ELMER SANDS LIMITED

Date 17 October 2017

M/94/17/PL - 72 Ancton Way, Elmer, Middleton on Sea. PO22 6JP

We write in respect of the planning application to demolish and rebuild 72 Ancton Way, Elmer.

SCALE:	As shown @ A3	
DATE:	July 2017	
DRAWN:	ASW	
CHECKED BY:	CW	
DRAWING NO:		
N265	PL02	*

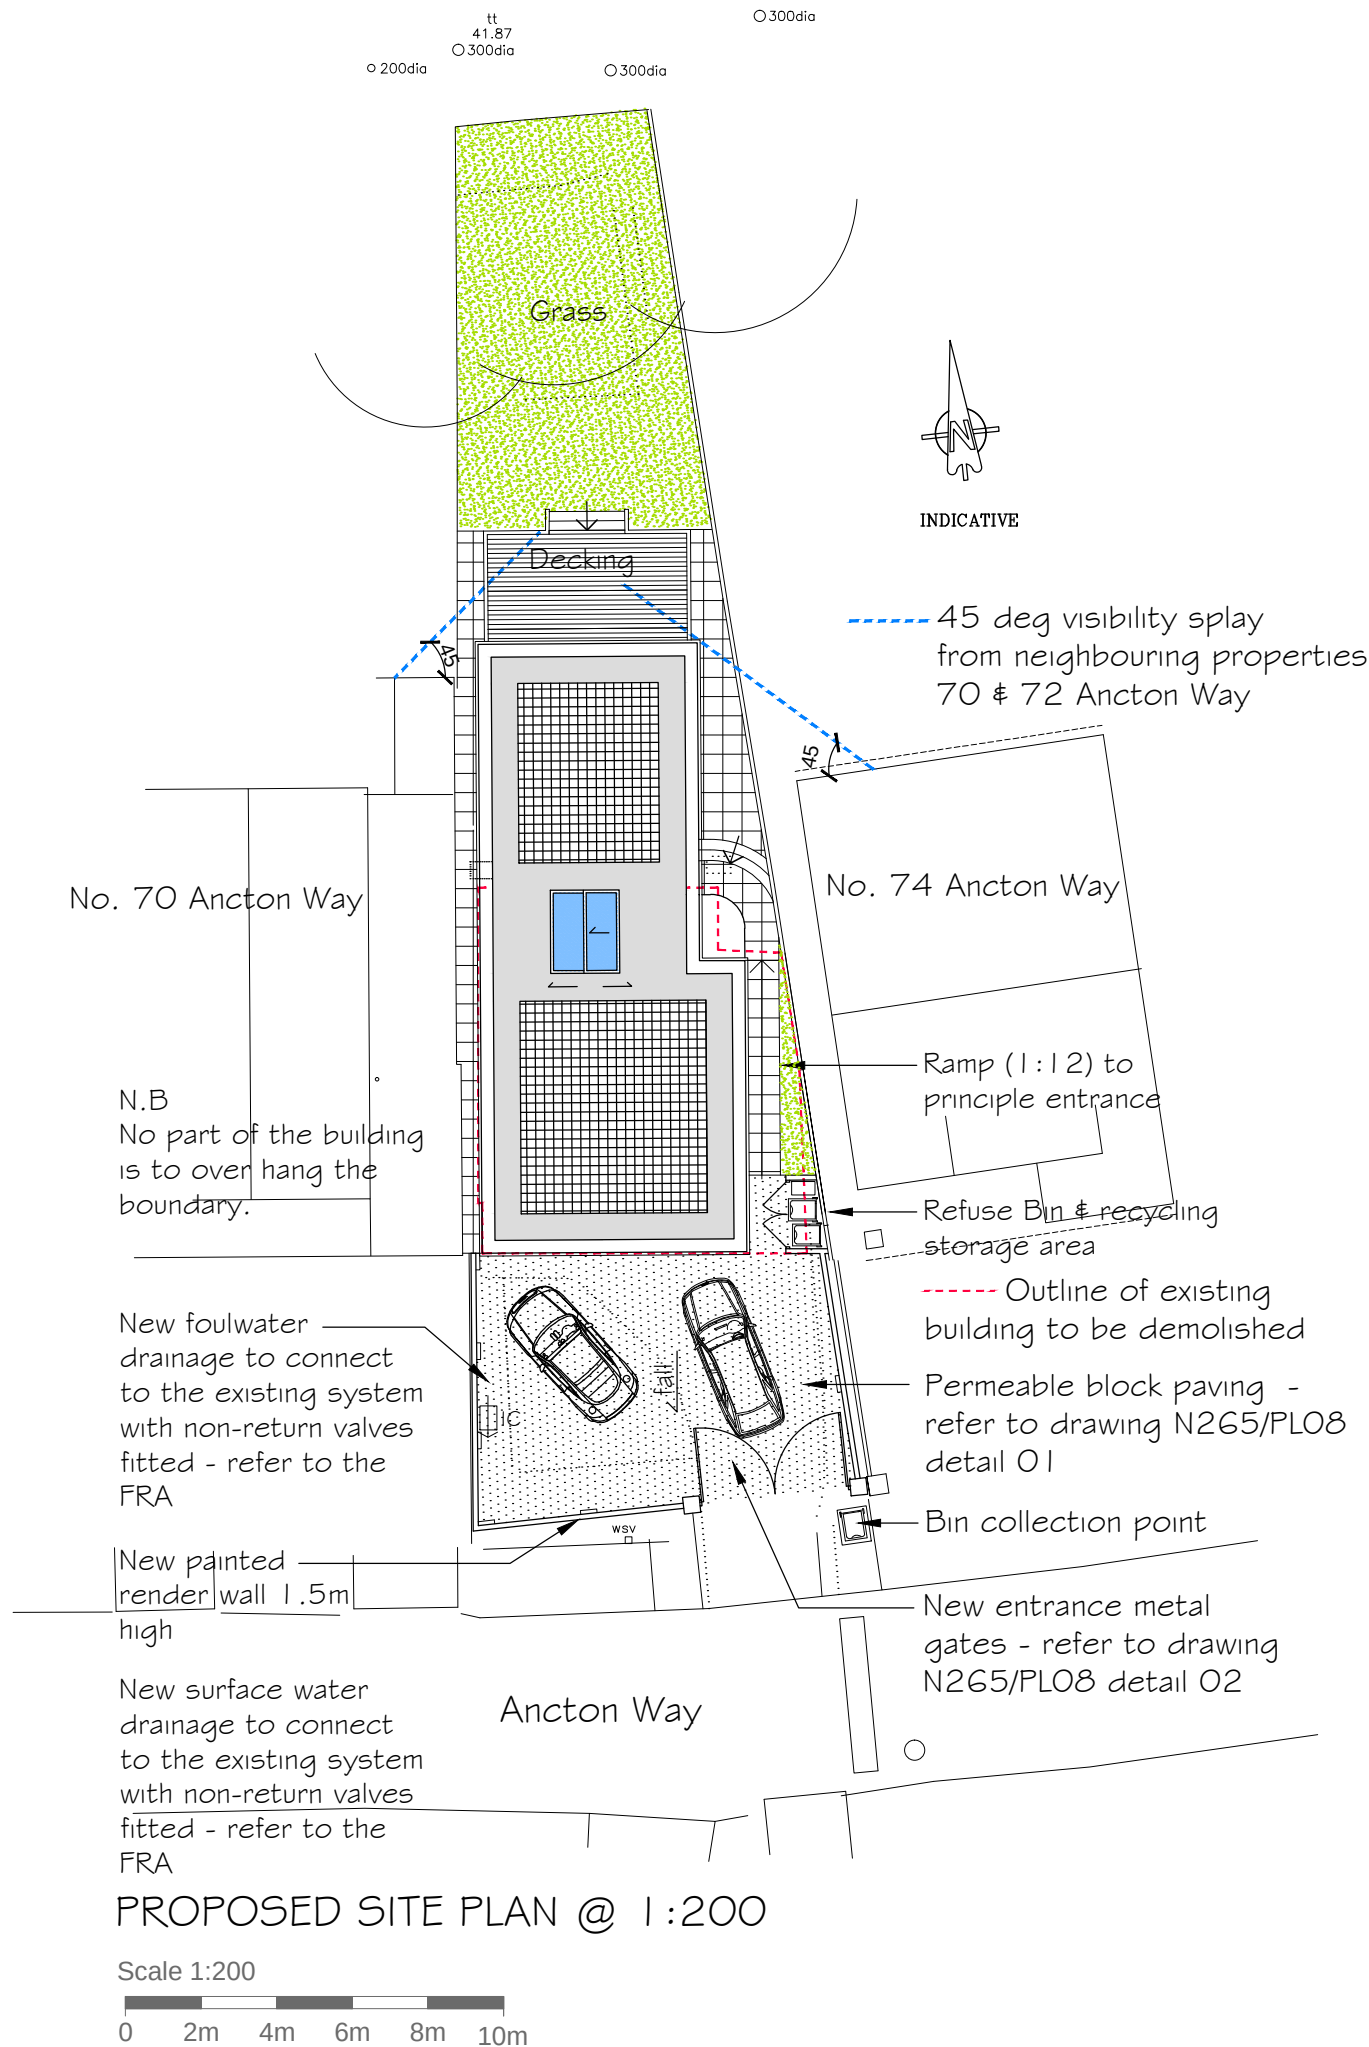
In item 12 of the application the statement is that surface water will be disposed of using the "existing water course". Also plan N265 PL02 states "New surface water drainage to connect to the existing system with non-return valves fitted - refer to the FRA". Paragraph 3.9. of the FRA states "Surface water drainage: the development's surface water will be routed into the sea, as per the existing site's surface water."

Whilst Paul Cann ADC has provided soak away and/or SUD specifications for the disposal of surface water, for clarity we need to state that connection to an existing surface water drain is not acceptable. The only one in the area being the surface water drain installed on Elmer Sands Limited land, to provide a course for water from the road surface, eastwards to the Ryebank Rife and on to the sea. This surface water drain does not have the capacity to carry water from Ancton Way properties or the wider area. Therefore there is no agreement to connect to this surface water drain owned by Elmer Sands Limited.
